City of Albuquerque Stormwater Construction Site Inspection Report

ESC File No.	C17E128	Project Name:	Starbucks - Alameda
NPDES Id. No.	NMR1003KD	Location:	8721 Washington St. NE
5/8/2023	Owner	Contractor	
Operator	Fair Plaza Associates		
Contact name & title	Sean McMullan		
e-mail	sean@mcmullanrealestate.com		
Contact Phone #	505-821-1662 C 259-6223		
COA Inspector	Doug Hughes	Start/End Time:	11am
Construction Phase:	Starbucks is open, site is inactive, stabilization complete		
Type of Inspection:	☐ Regular	☐ Storm Event	☐ Past Storm Event >0.25" ☐ 311/Complaint ☐ Follow Up
Weather at time of inspection?		clear	Temperature: ~ 70
Estimated date of last storm 0.25" or greater		3/16/2023

SHEET TITLE: Drainage Management Plan

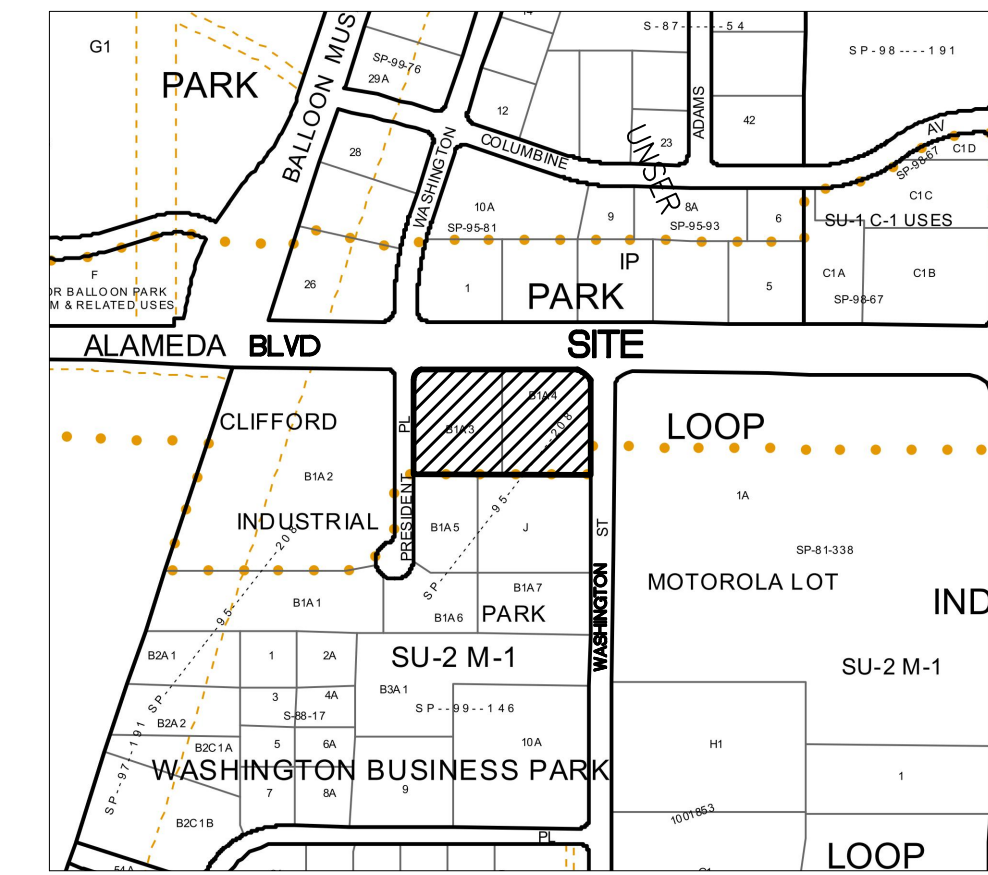
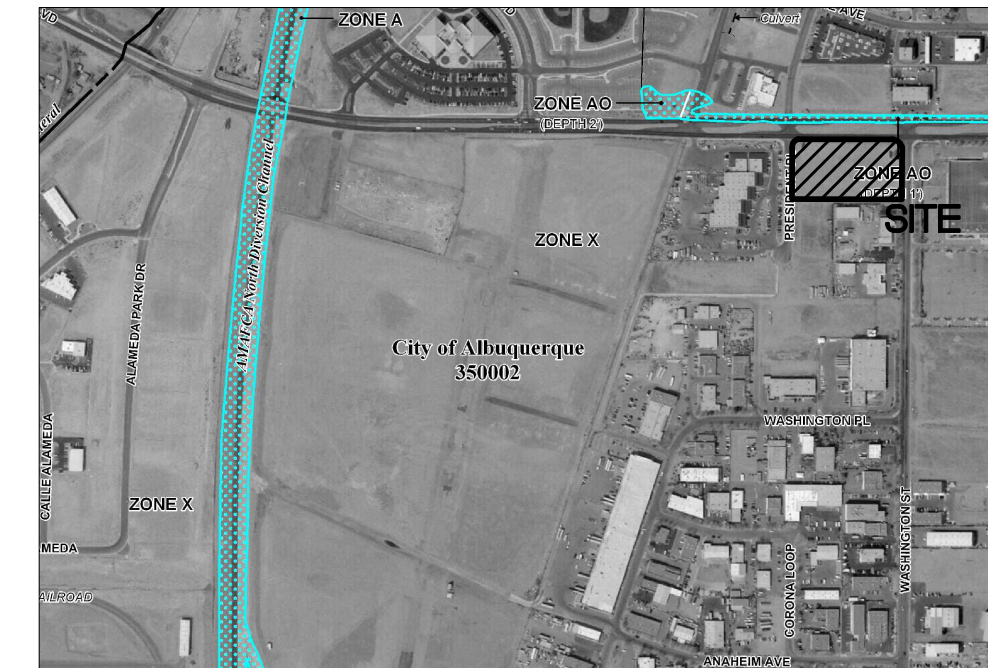
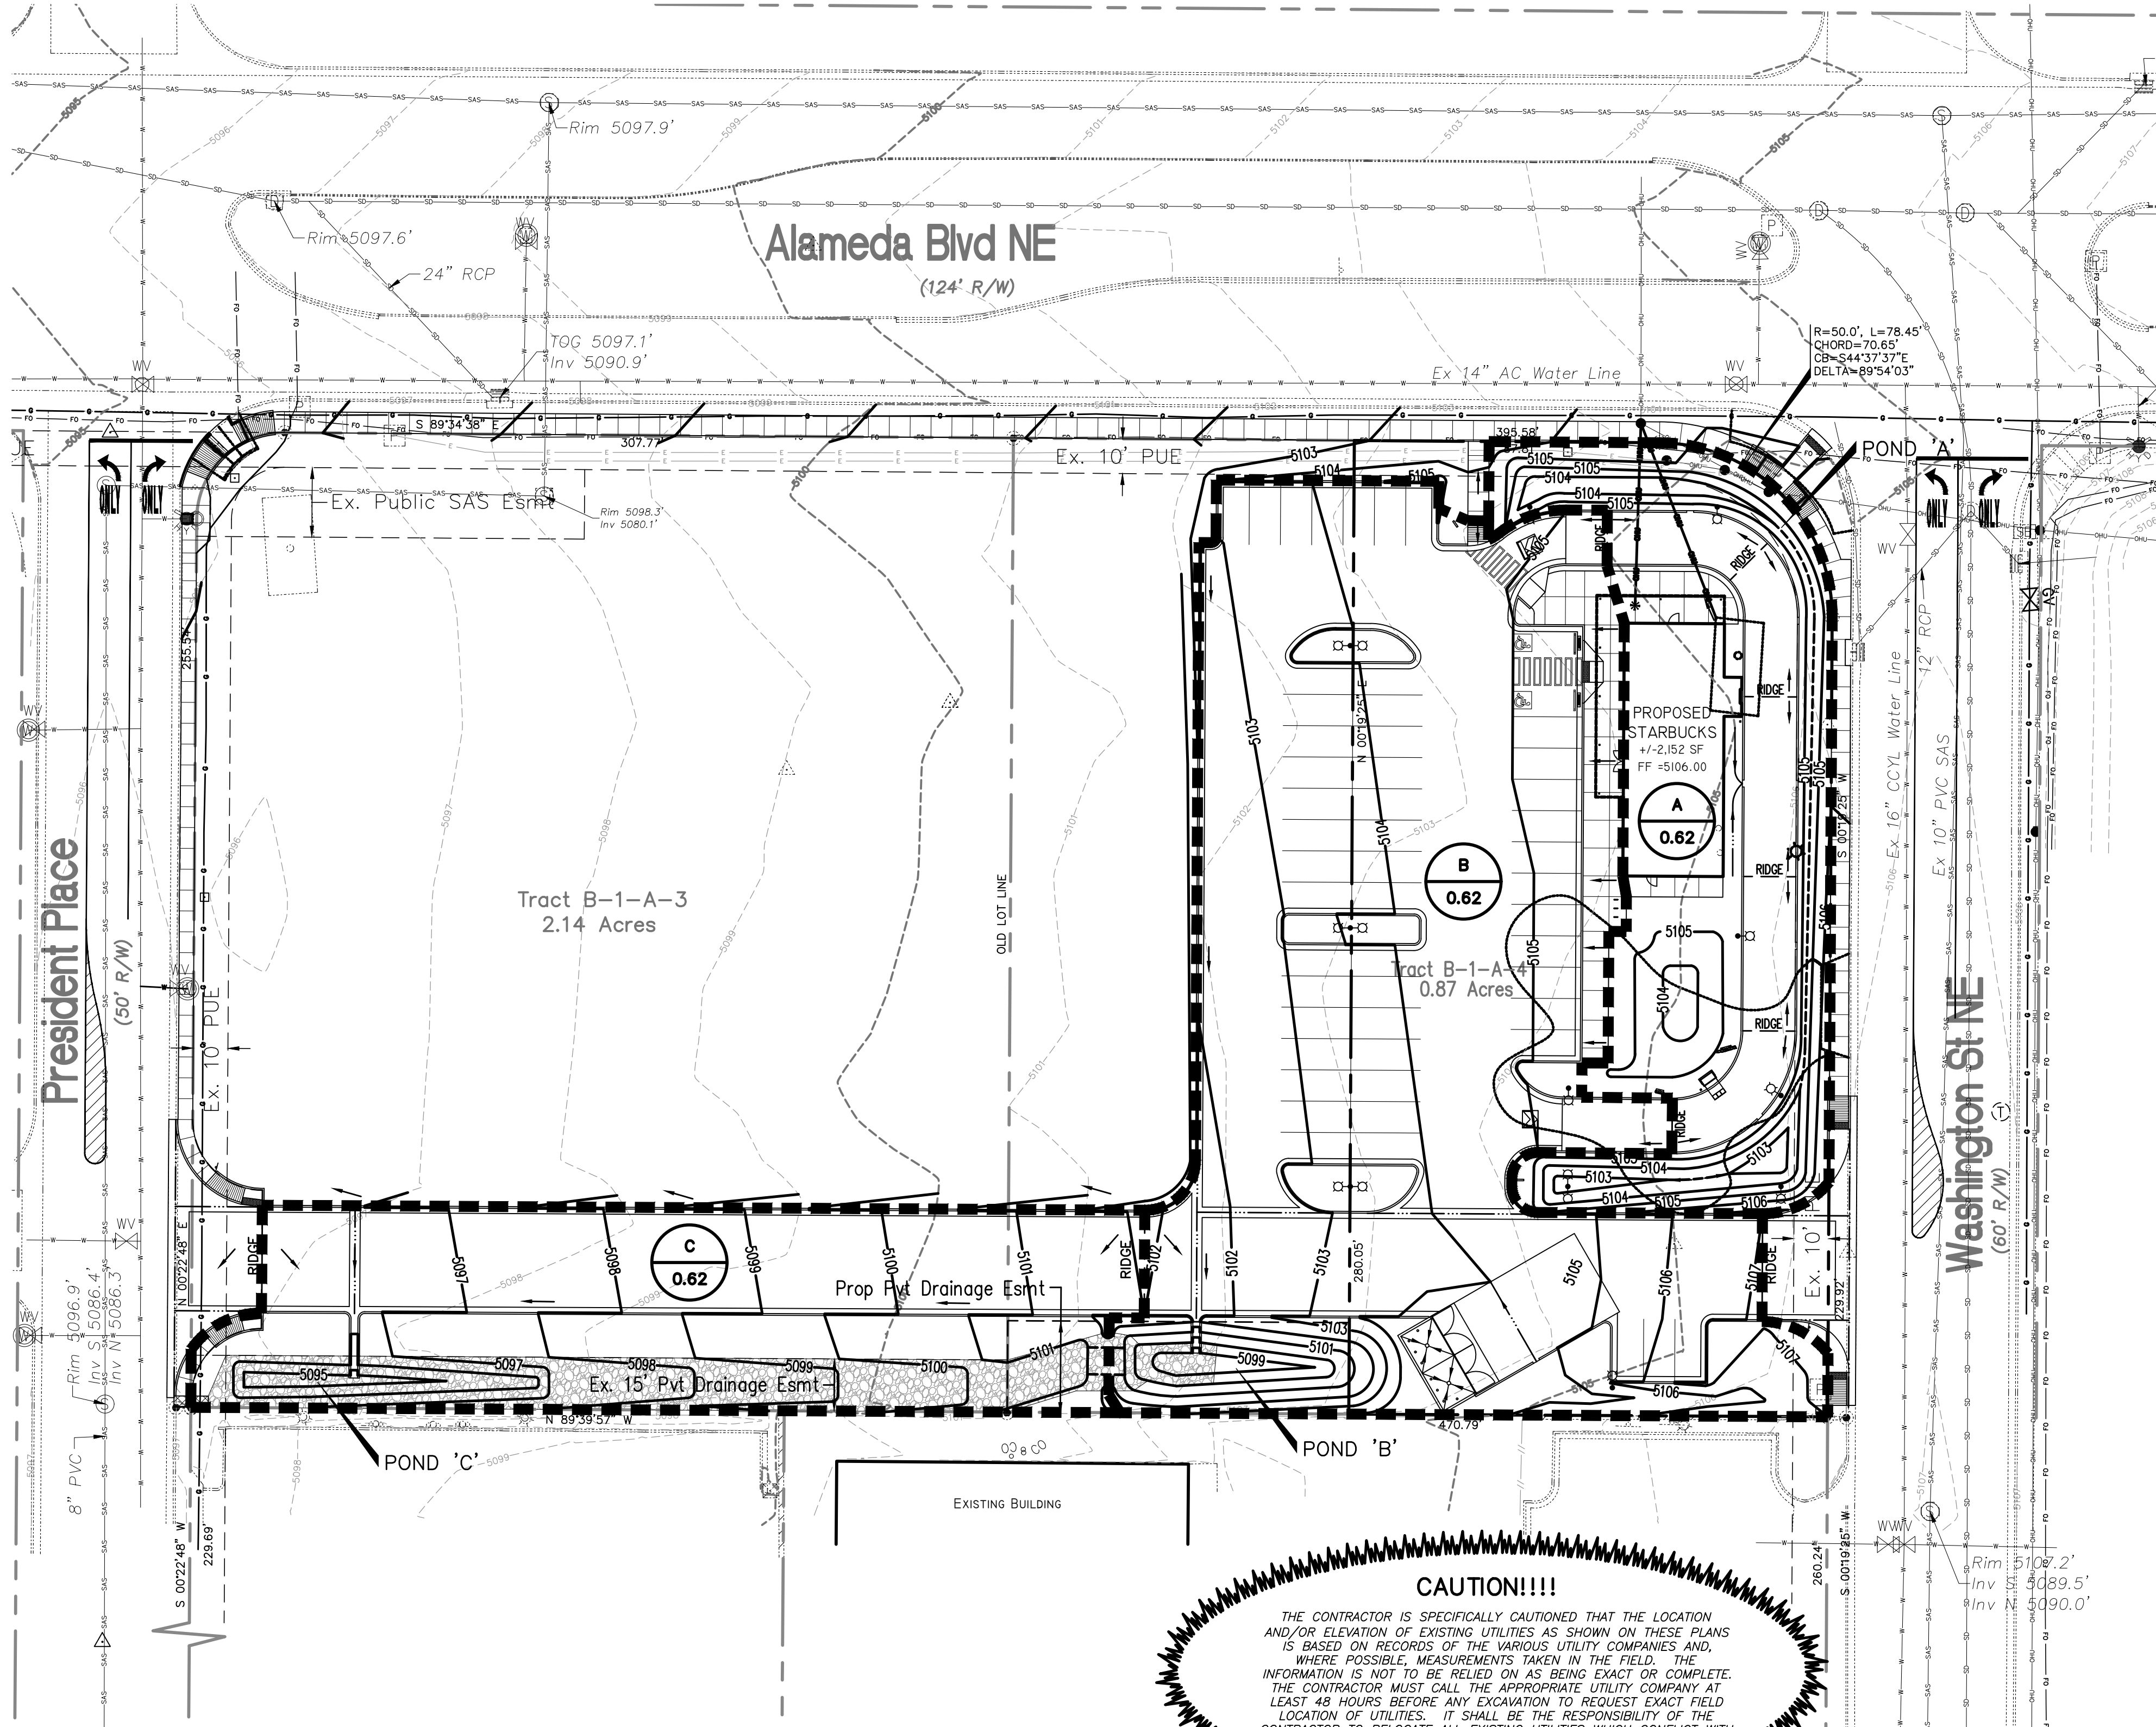
Item Number	Deficiency/ Corrective Action		
1	Coverage expired w/o terminating. Vegetation satisfies CGP 2.2.14.c so remove BMPs (silt fence) and position and terminate permit coverage per CGP part 8.		
2			
3			
4			
5			
2.1	Discharge off site? (Y/N)	yes	
4	Self Inspection Reports	missing	Latest report Date:
